Recommendation Report for Lawful Development Certificate for a Proposed Use or Development**REF NO:** BE/97/19/CLP**LOCATION:** 426 Chichester Road
Bersted
PO21 5DR**PROPOSAL:** Lawful development certificate for a proposed single storey rear extension.**DESCRIPTION OF APPLICATION**

The application seeks to construct a single storey rear extension.

REAR ELEVATION PROPOSED 1:100

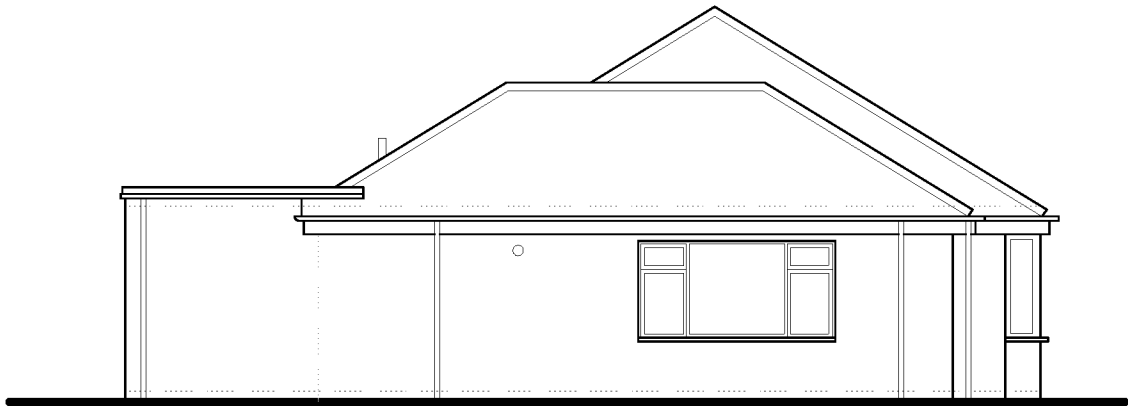
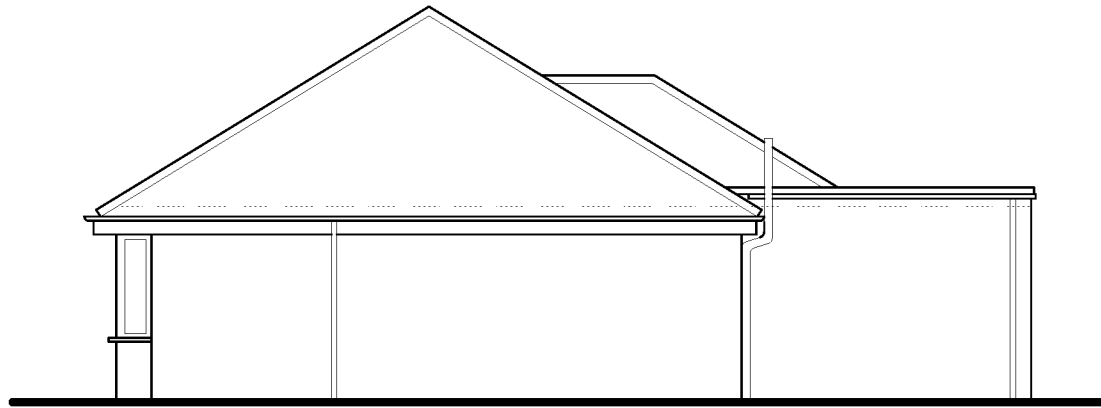
The proposed rear extension is considered to conflict with the limitations set out in Schedule 2 Part 1 Class A of the Town and Country Planning Permission (General Permitted Development Order) (England) Order 2015. The proposed eaves are considered to exceed the height of the eaves of the existing dwellinghouse.

- The proposed development conflicts with Schedule 2 Part 1 Class A (d) of the Town and Country (General Permitted Development) (England) Order 2015. The proposed eaves are considered to be higher than the eaves of the existing dwellinghouse.
